## Luminaire Schedule

# Lighting Plan\_v1.pdf Markup Summary

Project Name: 7630 Ben Grass Meadow Drive

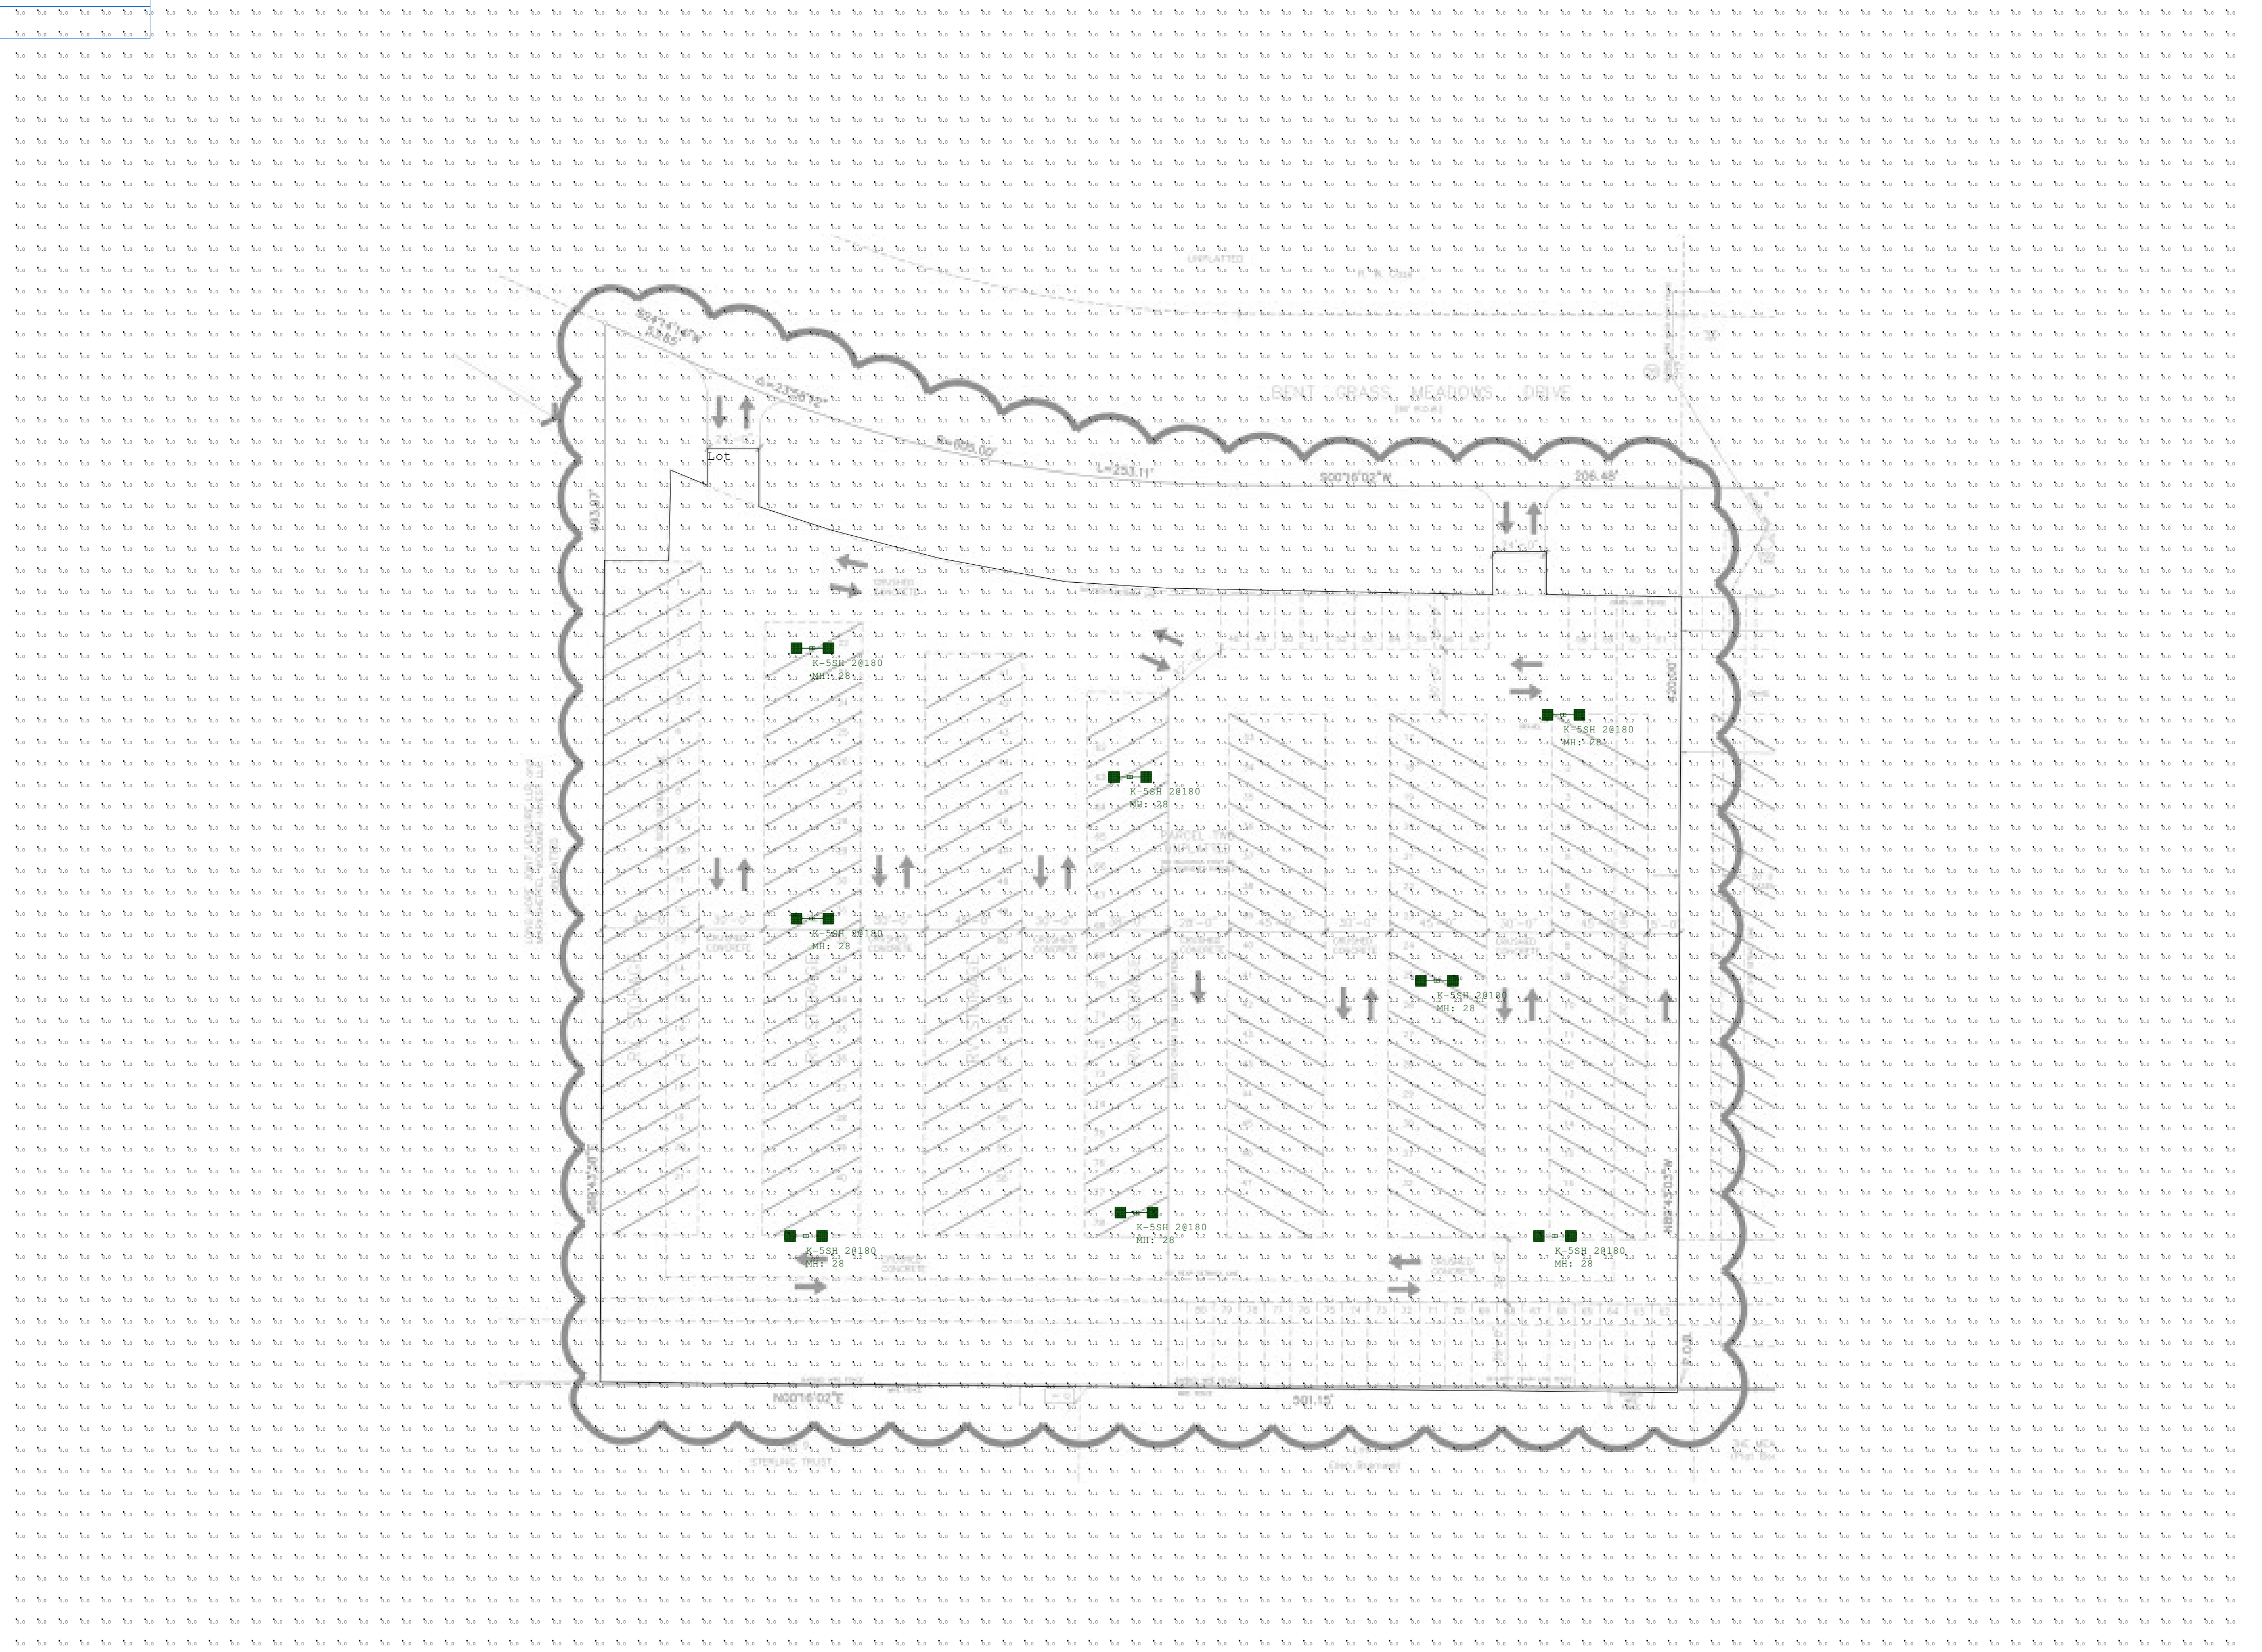
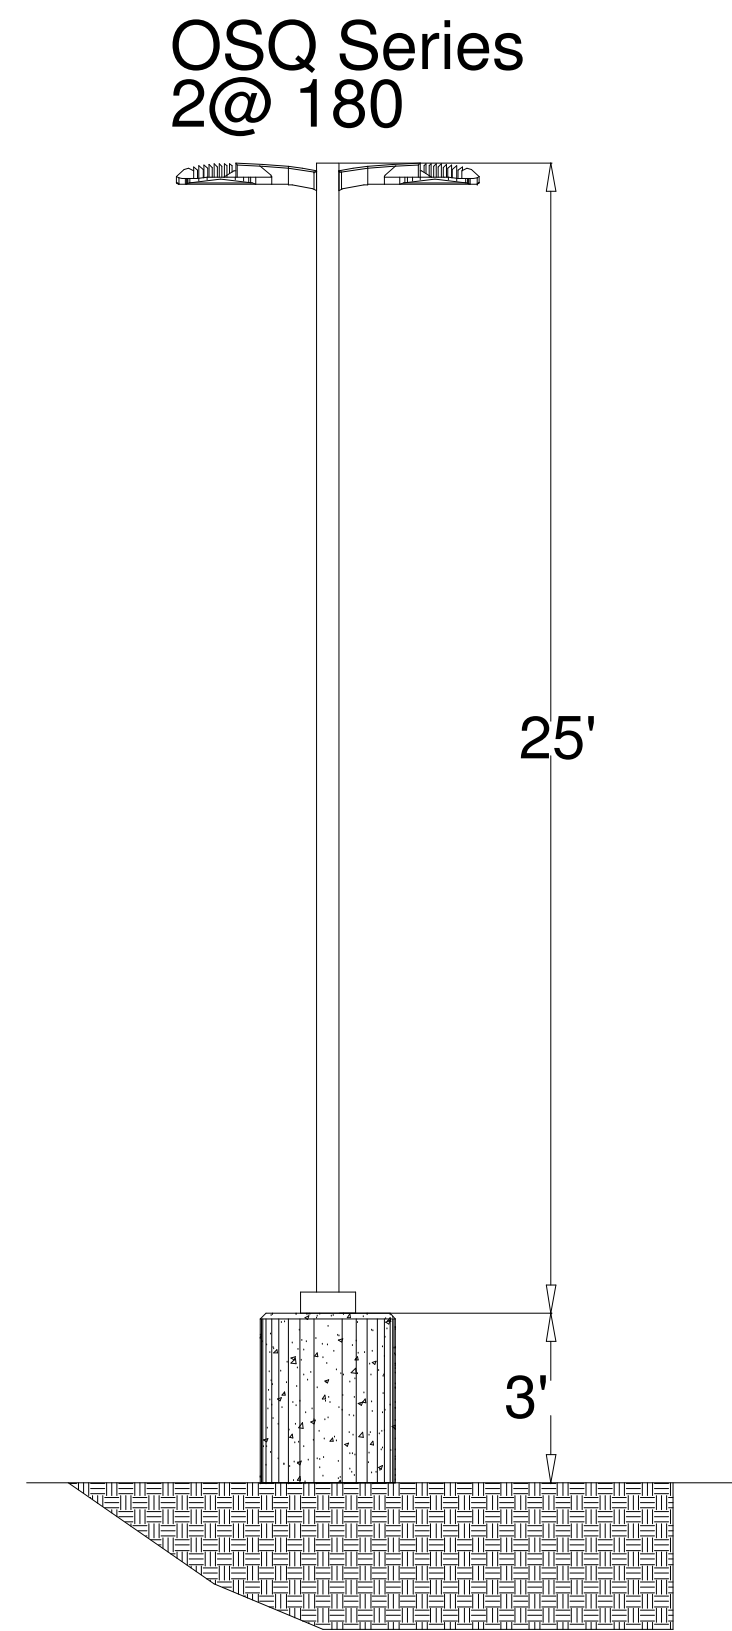
-Please depict the owner/applicants: name, phone number, and email

-Please depict a north arrow on this plan

-Cannot exceed a maximum height on 20 ft, if you plan to exceed please follow alternative lighting plan requirements and state in letter of intent

-A building footprint for all structures depicted and labeled

-The location and height of all illumination devices, including but not limited to all parkings areas and external light structures

-Please provide a detailed description for the illuminating devices,lamps,supports,reflectors, installation, and electrical details the descriptions may include but are not limited to specifications and catalog cuts sheets and drawings

-Photometric data and plan, including maps and diagrams furnished by manufacturers or similar showing the angle of the cut off or emission

-Location of all existing and proposed easements, if there are none, please specify

Lighting:

Section 6.2.3 of the LDC
